### Department of Transportation

RE: Waterbury Filings Nos.1 and 2 PUD PP - PUDSP215

The Traffic Impact Study dated September 28, 2021 has been reviewed by a CDOT Traffic Engineer. Their comments follow:

The Master Development Drainage Report and Final Drainage Report for subject development dated September 2021 has been reviewed by a CDOT Hydraulics Engineer. Their comments follow:

DETENTION FACILITY 1

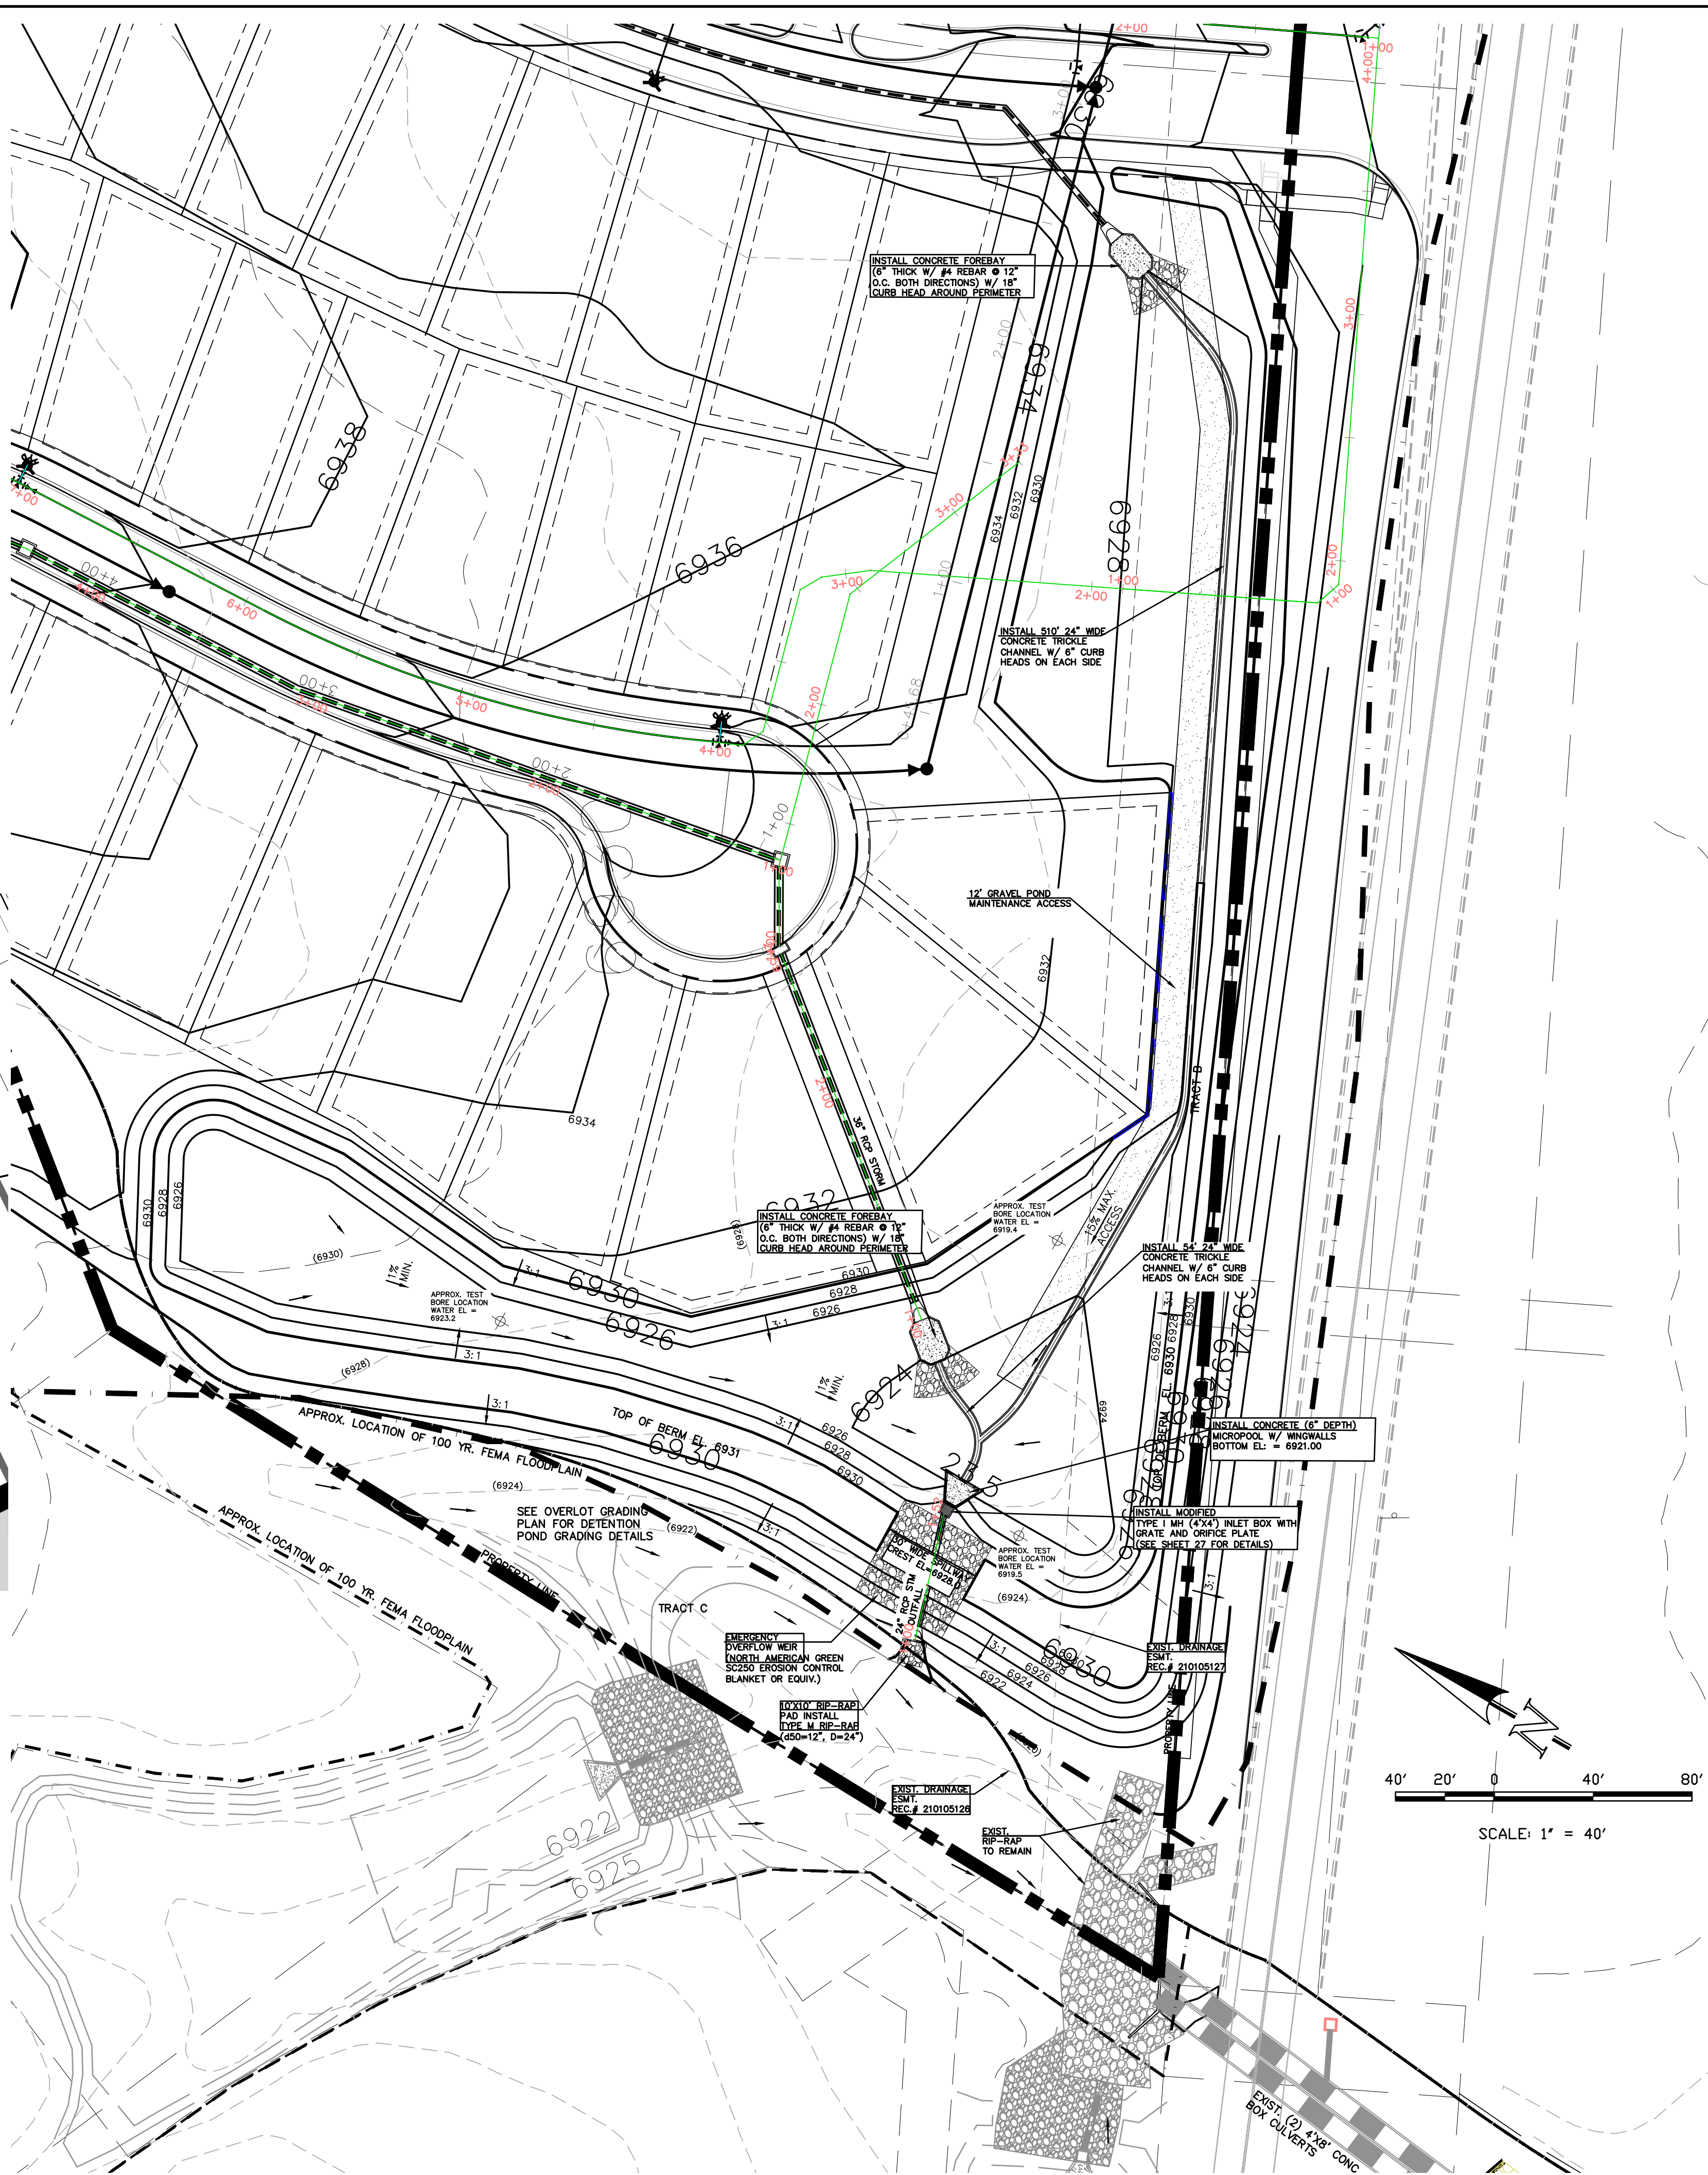
- The Pond 1 Routed Hydrograph Results (page 129 of 302) should show a Ratio Peak Outflow to Predevelopment of 1.0 for all storm events. Please revise the outlet structure design to lower the discharge for the events that are above 1.0.
